# Sheringham Shoal and Dudgeon Offshore Wind Farm Extension Projects

## Pre-examination Response to s51 Advice and Comments of the Planning Inspectorate - Cover Letter

October 2022  
Document Reference: 10.1  
APFP Regulation: 5(2)(q)

**Planning Act 2008 – Application for Development Consent  
Sheringham Shoal Offshore Wind Farm Extension Project and Dudgeon Offshore  
Wind Farm Extension Project  
PINS Reference: EN010109**

Sheet 18

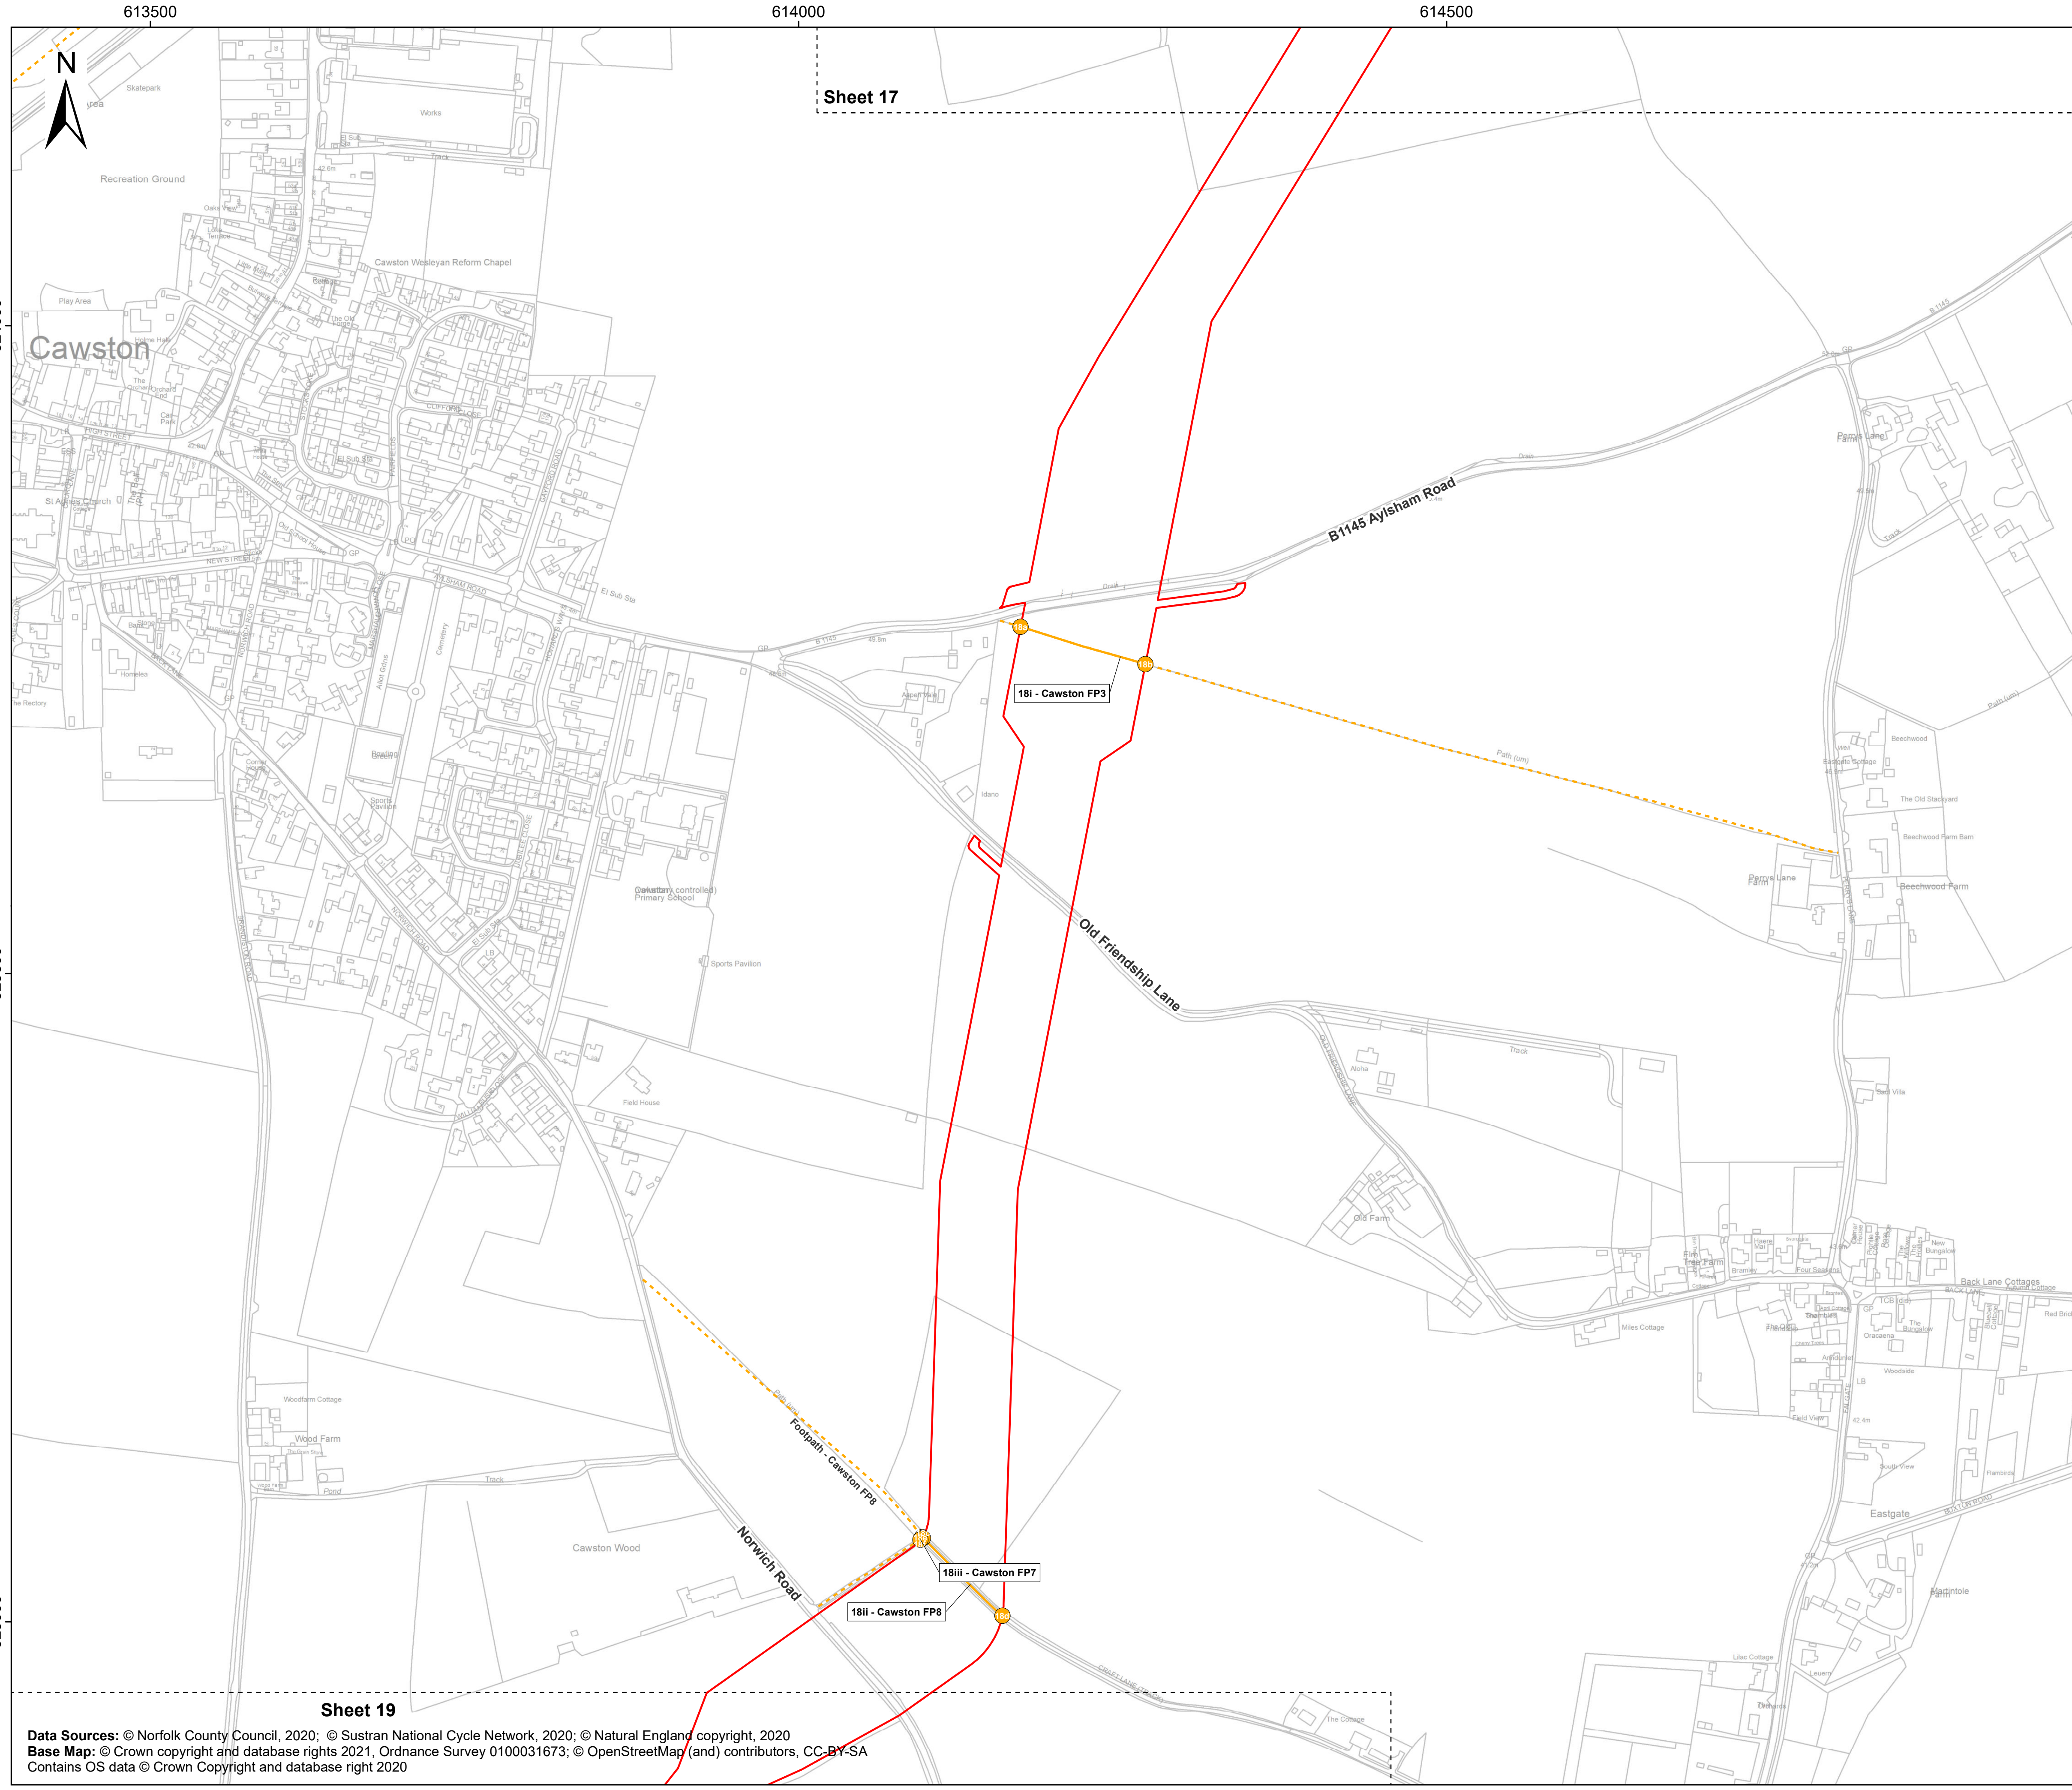
<p>12. There is a discrepancy between the Public Rights of Way (to be temporarily stopped up) Plan (Doc 2.11) and the Development Consent Order (Doc 3.1), where the Development Consent Order (Doc 3.1) makes reference to points marked 18e and 18f on sheet 18, however these points are not visible on the Public Rights of Way (to be temporarily stopped up) Plan (Doc 2.11). Additionally, there are other reference points missing labels on the Public Rights of Way (to be temporarily stopped up) Plan (Doc 2.11), for example, points 22d, 35b and 37g.</p> <p><b>Planning Statement (Doc 9.1)</b></p>	<p>(document reference 3.1). The legend has been corrected to refer to schedule 5, rather than schedule 4.</p> <p>The Applicant has reviewed the Public Rights of Way (to be temporarily stopped up) Plan (document reference 2.11) and has amended this to include the missing reference points.</p>
<p>13. In the Planning Statement (Doc 9.1) the citation of tables included in part of the Statement appears to have been omitted in the submitted version.</p>	<p>The Applicant has reviewed the Planning Statement (document reference 9.1) and corrected this omission.</p>
